Luminato, 169 Newbury Street - Final Traffic Comments

Hi Caitlin – The following is a status update from my preliminary review and represents my final traffic comments.

**5 BITUMINOUS DRIVEWAY APRON (I-13)**  
NOT TO SCALE

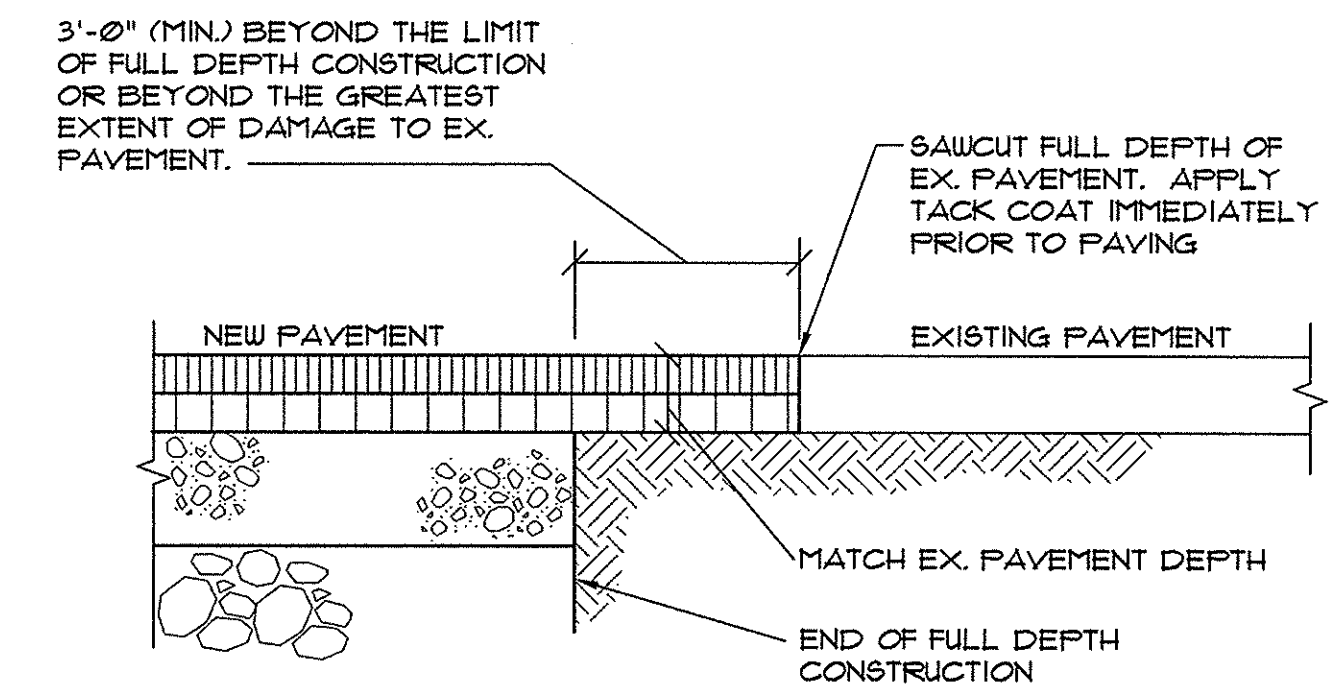
- Based upon my review of site characteristics the proposed project is not expected to cause unreasonable highway or public road congestion or unsafe conditions with respect to impacts to the public street system.
- The driveway apron on Newbury Street shall be designed so that a maximum 2% cross-slope is constructed for pedestrians walking along Newbury Street.
